Subject: Eagle Rising SP205 Preliminary Plan Reinstatement

Submittal Name:		EDARP Review Comments													
Project Name:		SP205 - Eagle Rising Preliminary Plan Reconsideration													
		Wednesday, January 17, 2024													
Previous Comment Number ID	New Comment Number ID	Document Submitted	Agency	Attachments	Reviewer Name	Reviewer Date	Redline Document	Page	Reviewer Comment	Applicants Disposition	Applicant Response Date	Document	Page	Applicant Comment/Response	El Paso County's Response to Applicant's Responses
1	1	N/A	PCD Engineering Division	Yes	Jeff Rice	11/20/2023 13:25	SP-20-005 – Eagle Rising Fifth Submittal (2022/2023 fourth review)	1	SP-20-005 – Eagle Rising Fifth Submittal (2022/2023 fourth review)	C - Disapproved	1/17/2024	N/A	N/A	<p><b>No written EPC response to applicant's 11/3/2023 response to 9/29/23 EPC</b></p> <p>July 29, 2022 submittal not listed in EDARP</p> <p>Aug 30, 2022 responses not listed in EDARP as new files opened</p> <p>Curiously Comments, Red Herring comments received 3/1/2023 9:20:32 PM</p> <p>Preliminary Plan previously accepted</p> <p>Responses to EL Paso County comments are not considered a new submittal</p>

EAGLE WING DRIVE (PUBLIC) & EAGLE WING VIEW (PRIVATE)
 STA 1+54.66 TO 3+35.96 & STA 3+35.96 TO 11+92.62

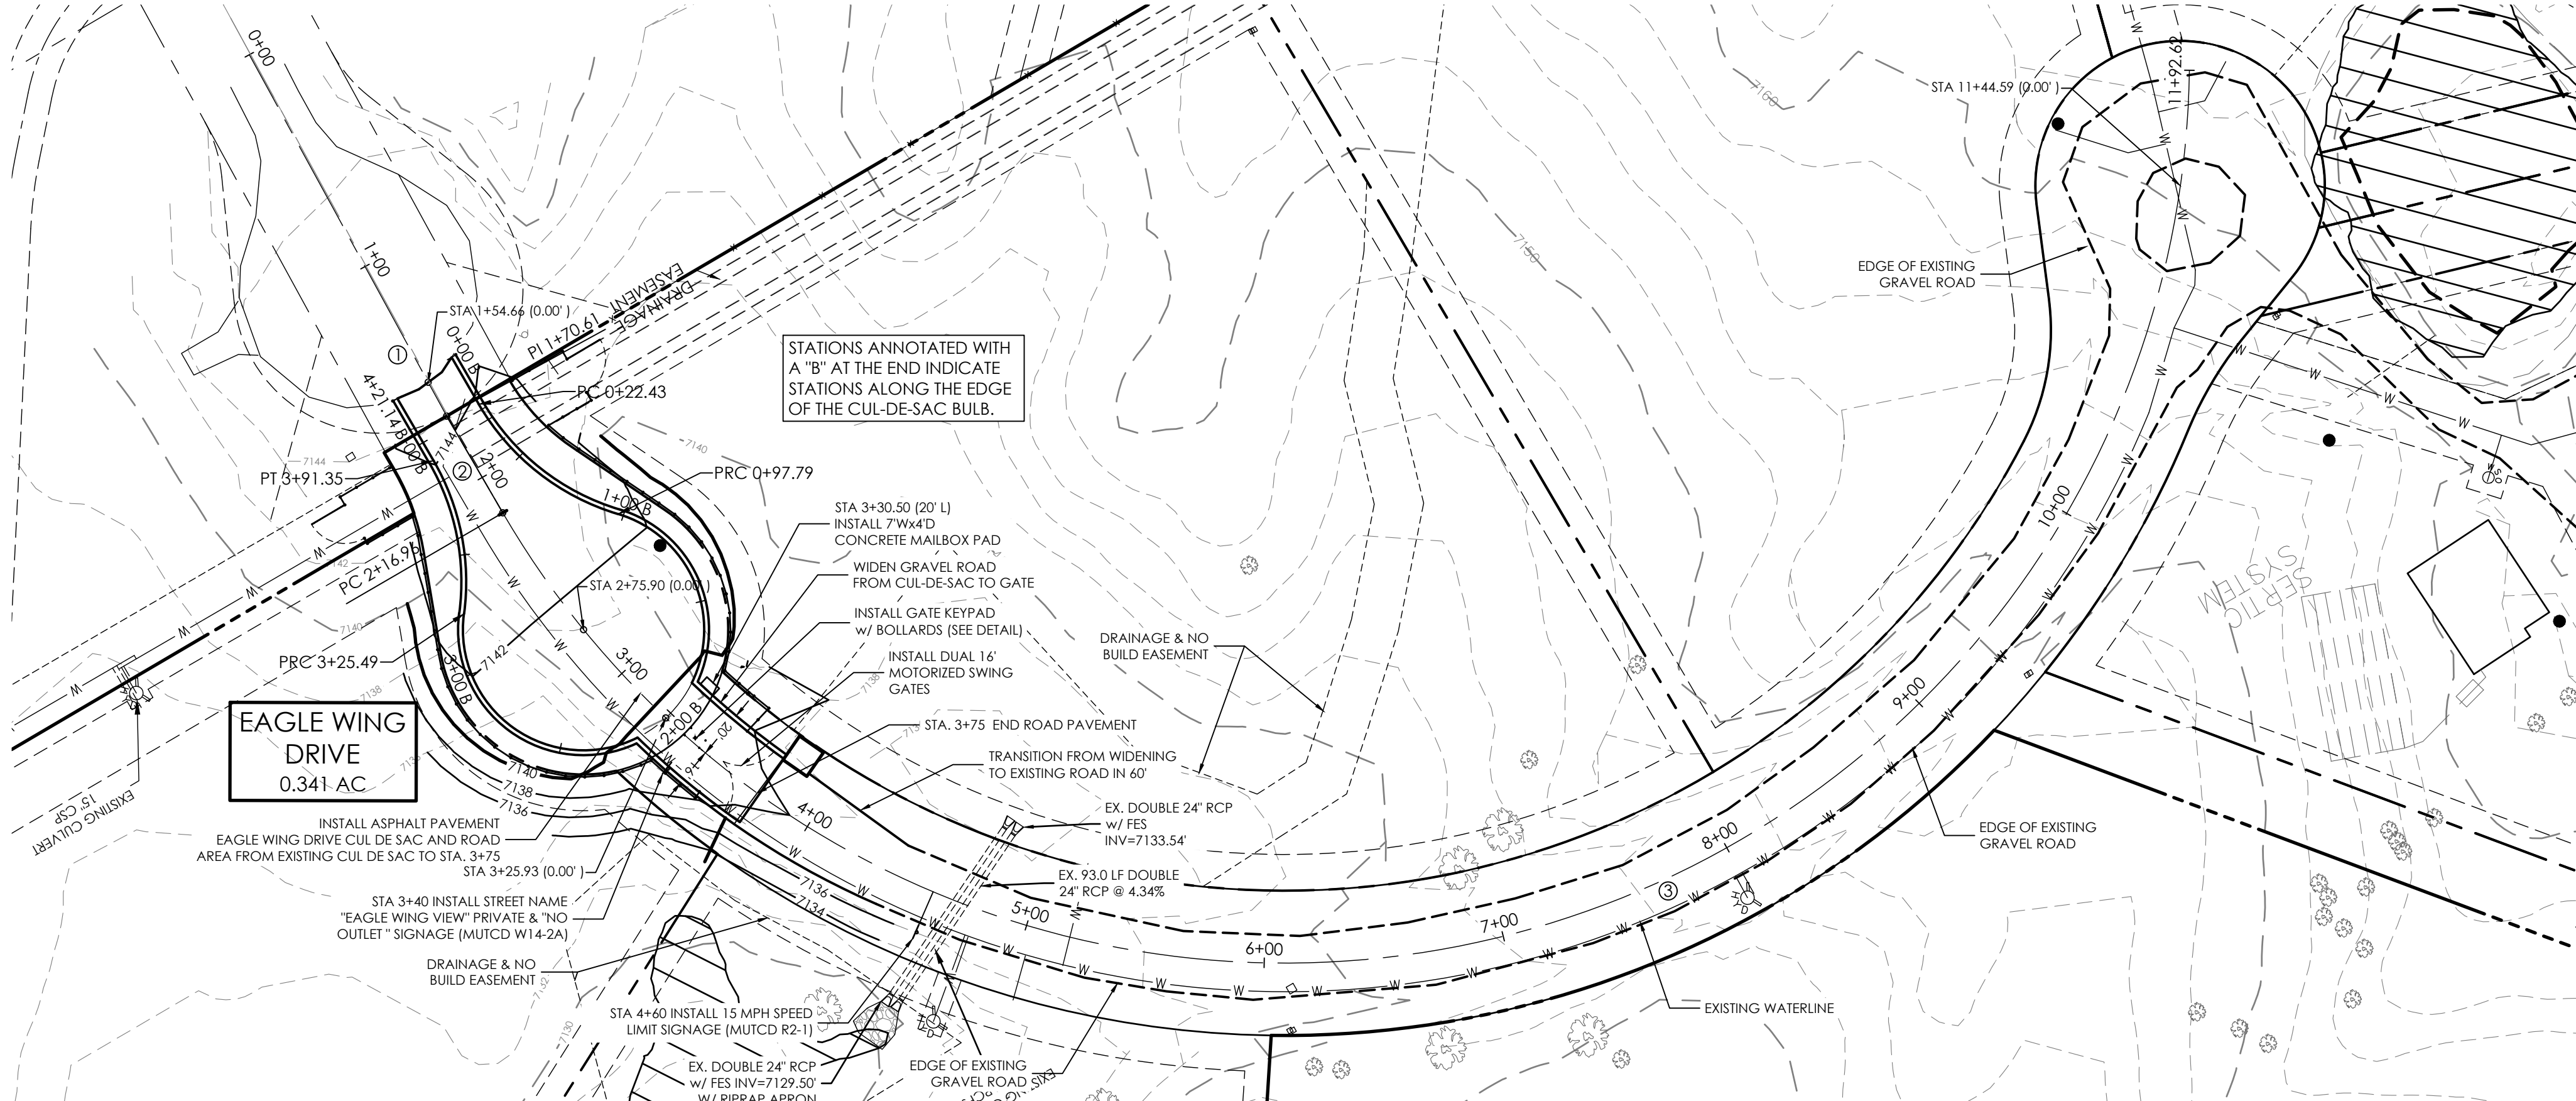
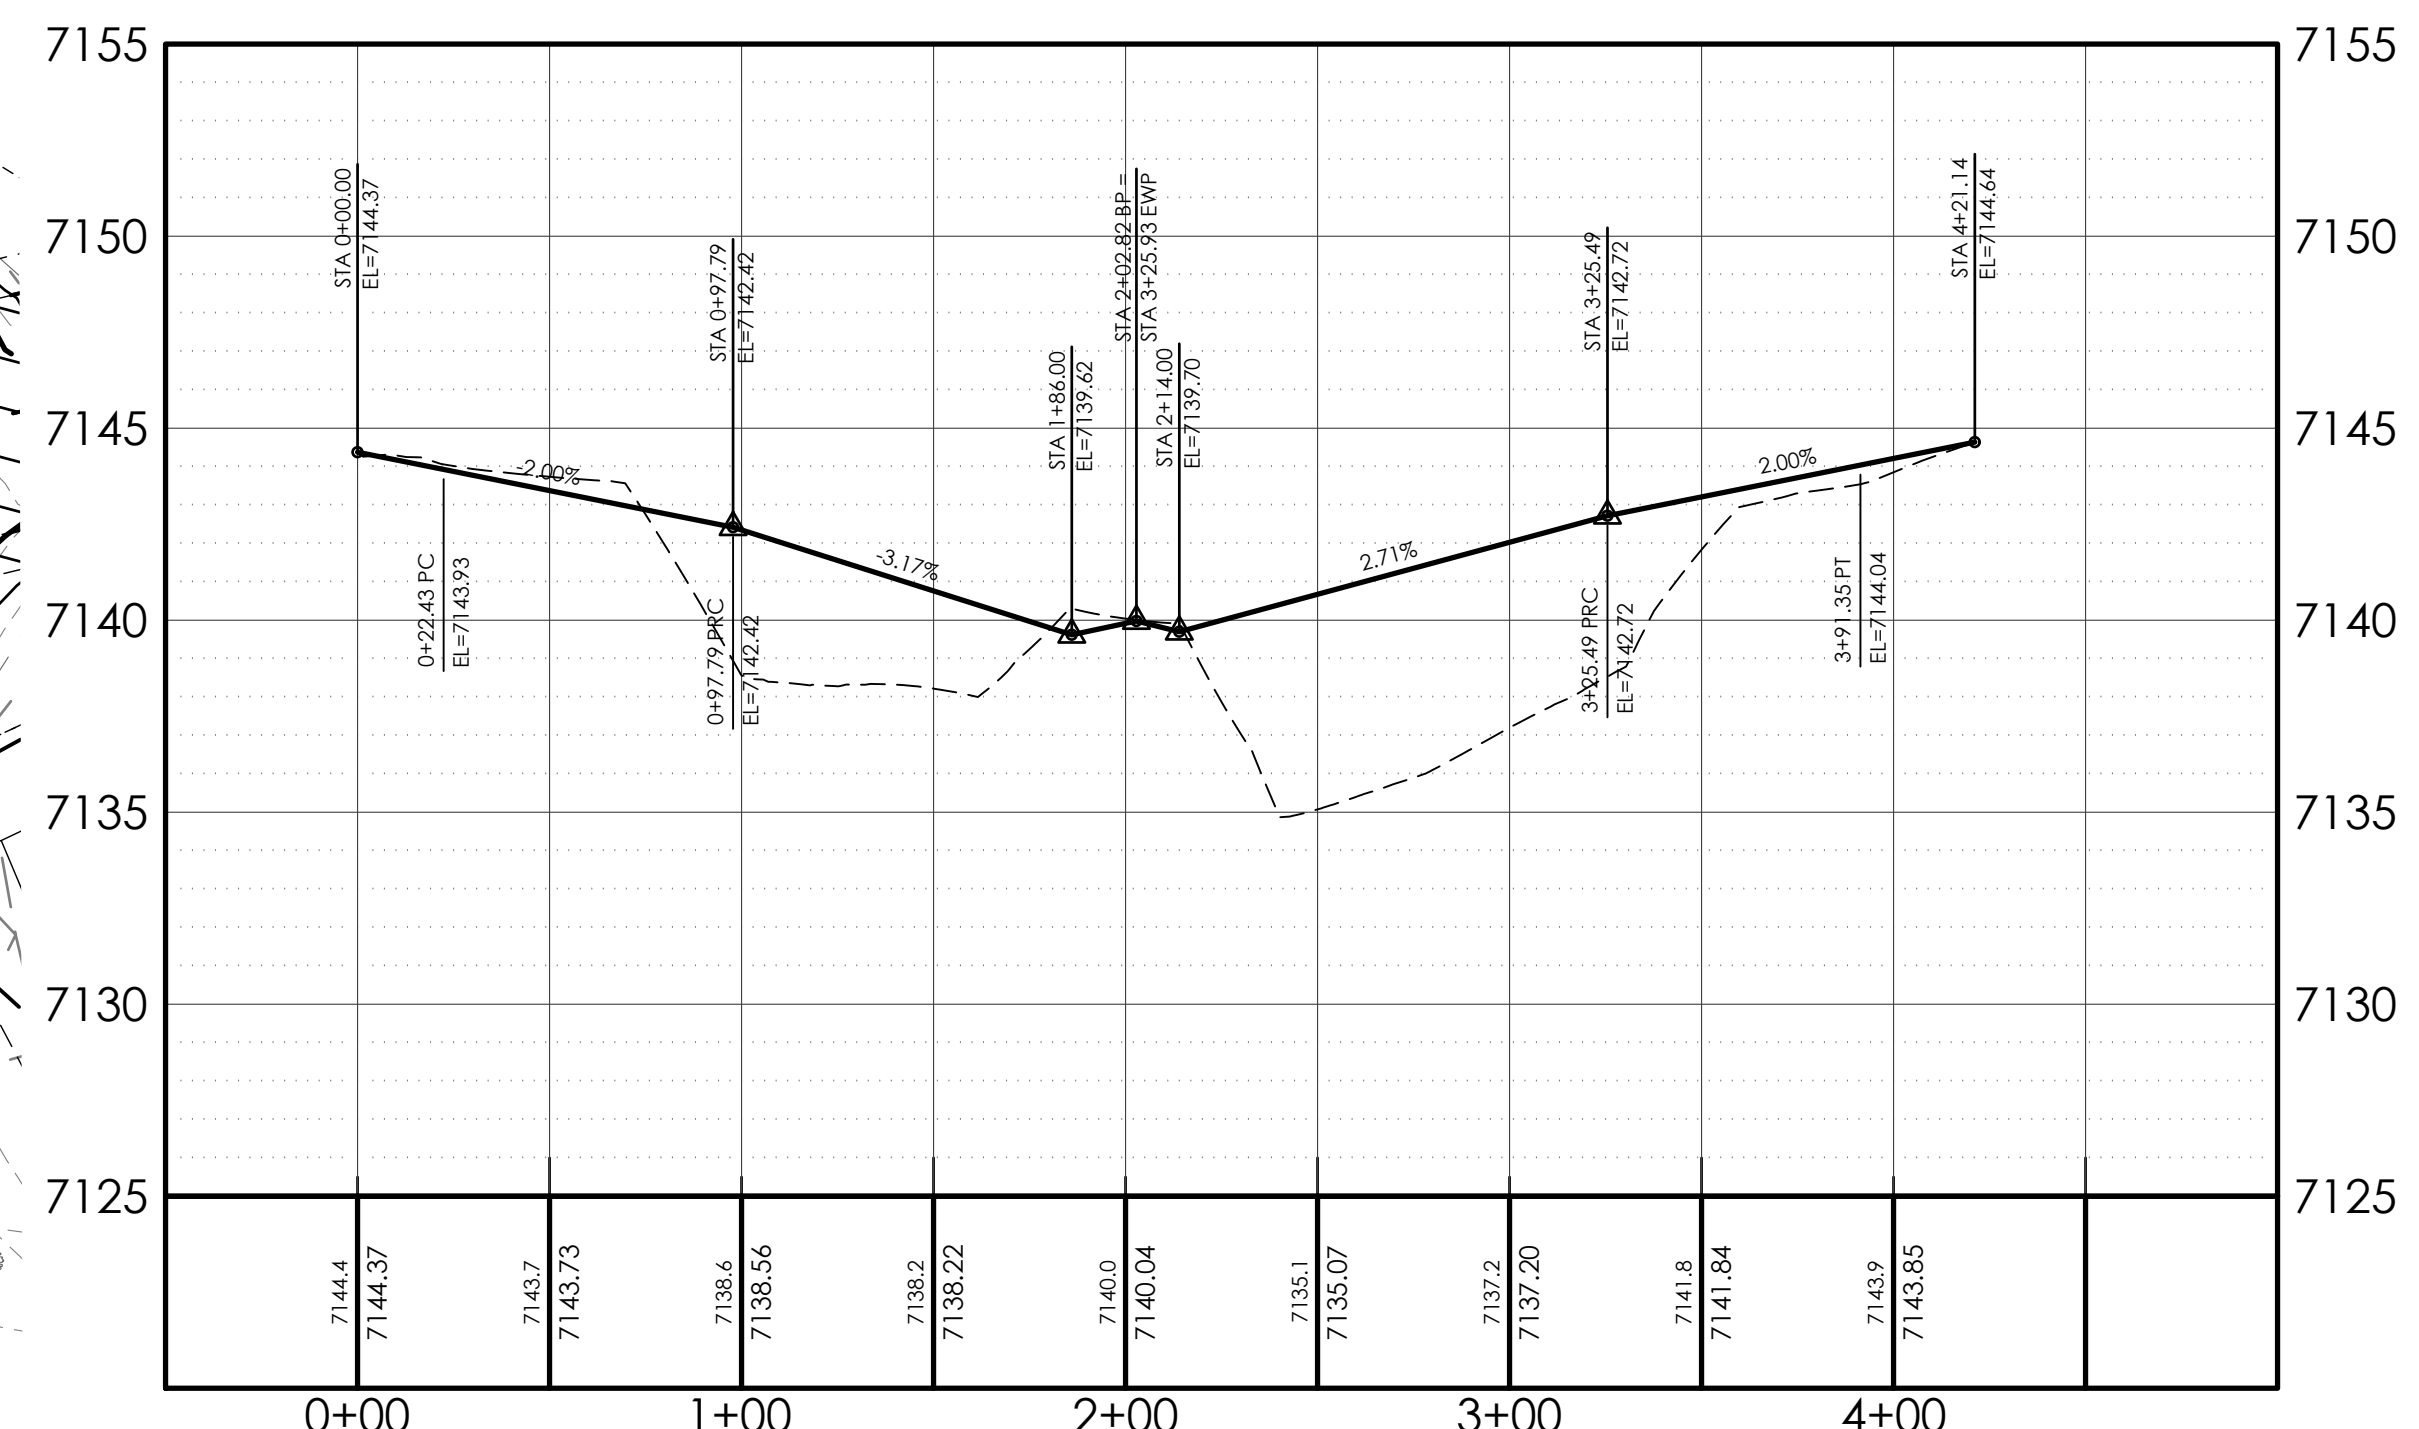
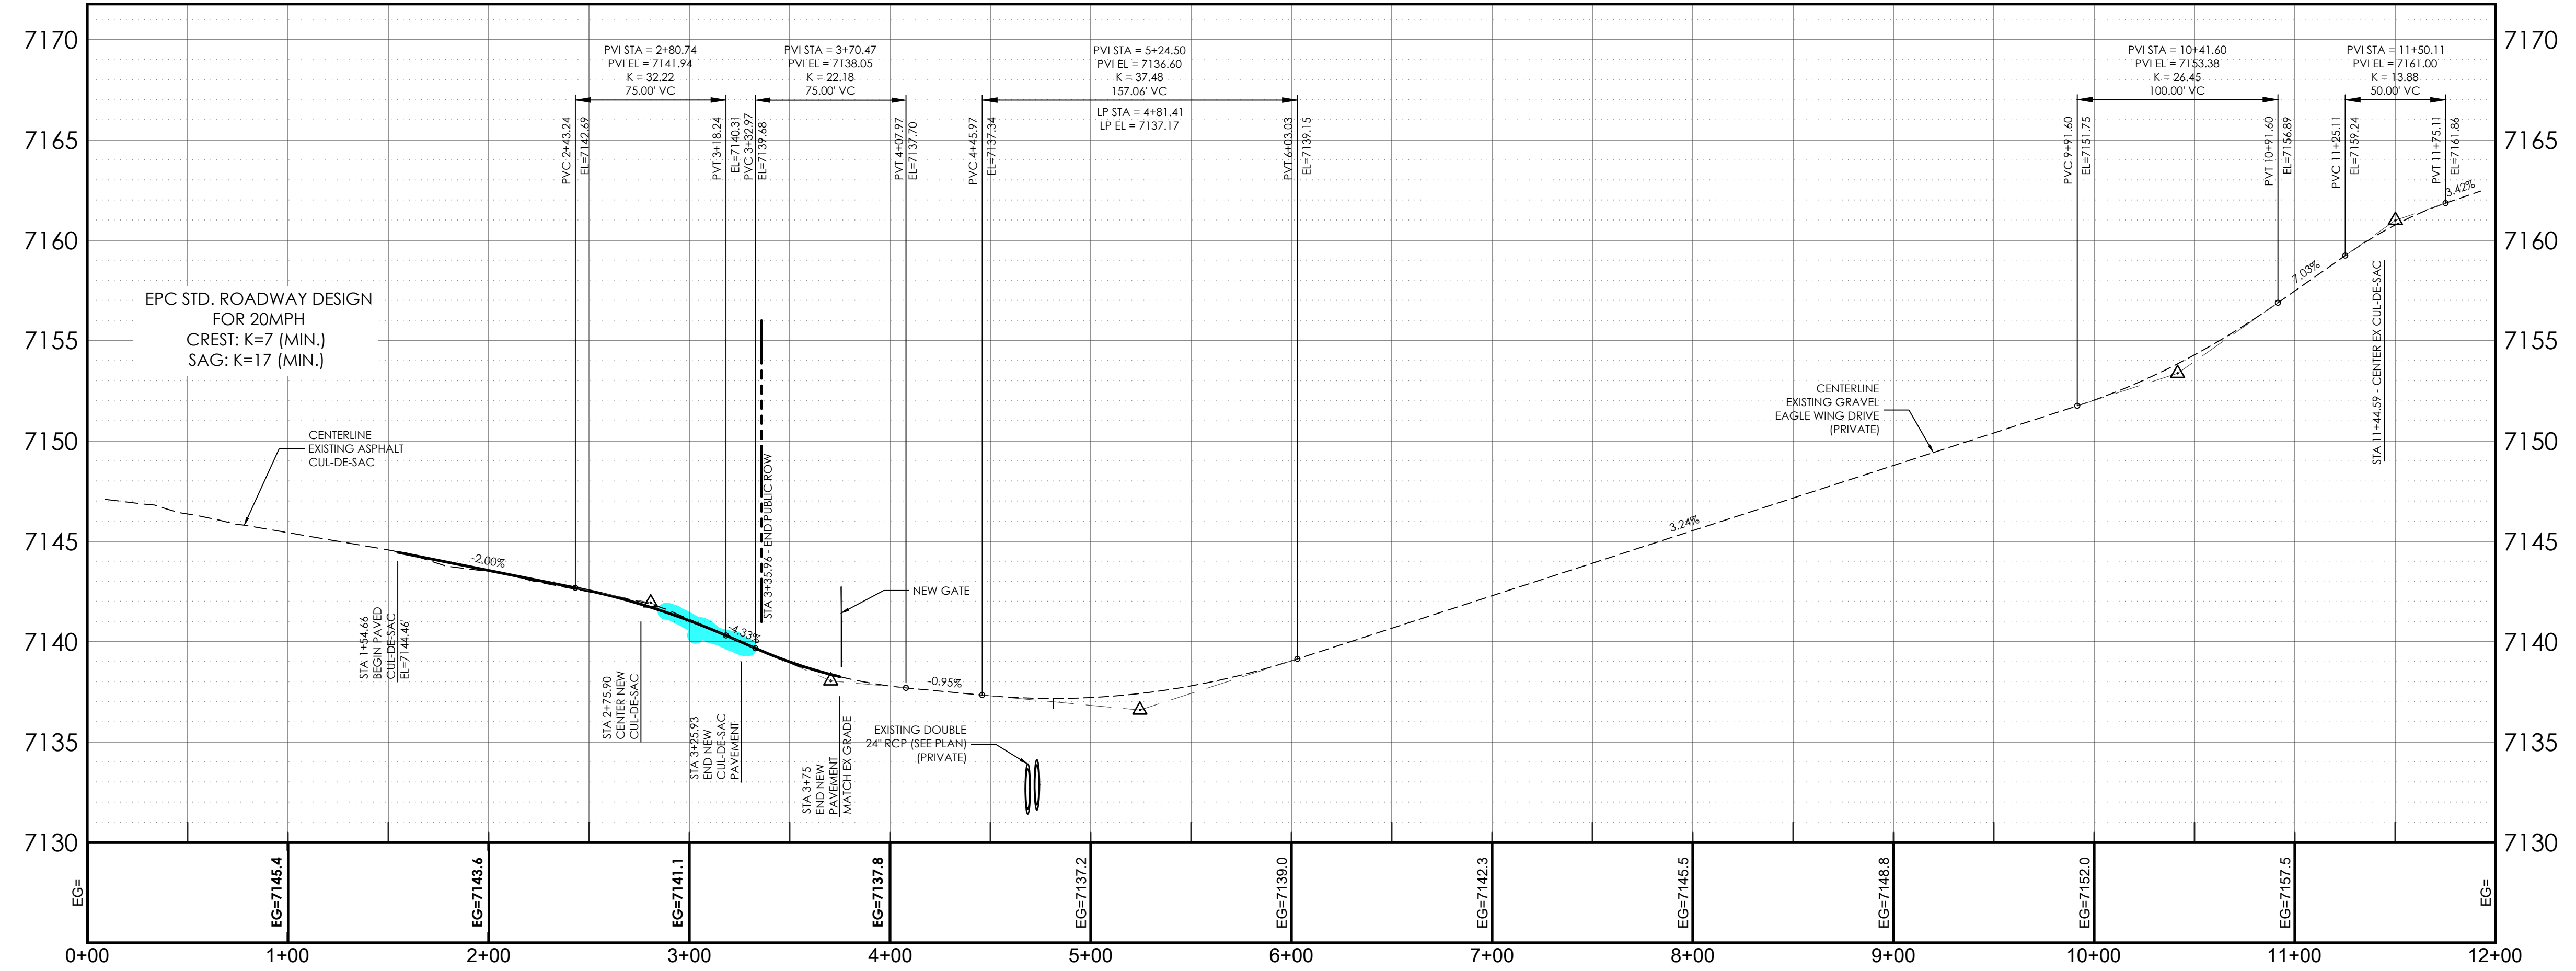
Gorman, Rice	O	O
Prelim Plan Comment 4	<p>Private Gravel Road Deviation with cross section was provide and shown. Rice to review what was uploaded to EDARP on 11.3.2023. A Deviation update will be uploaded to EDARP. Note that the BFFD fire trucks have used this Cul-de-Sac without a problem with grade or size.</p> <p>Approve deviation requested.</p>	Gorman	O	O
		Rice to review. Palmer to approve	O	O
	<p>Once the Engineering comments are satisfied to meet the requirements set forth in the BoCC Resolution. Administrative Approval of the Preliminary Plan is requested.</p>	Palmer to verify.	R	O
		Herrington to Approve	R	O
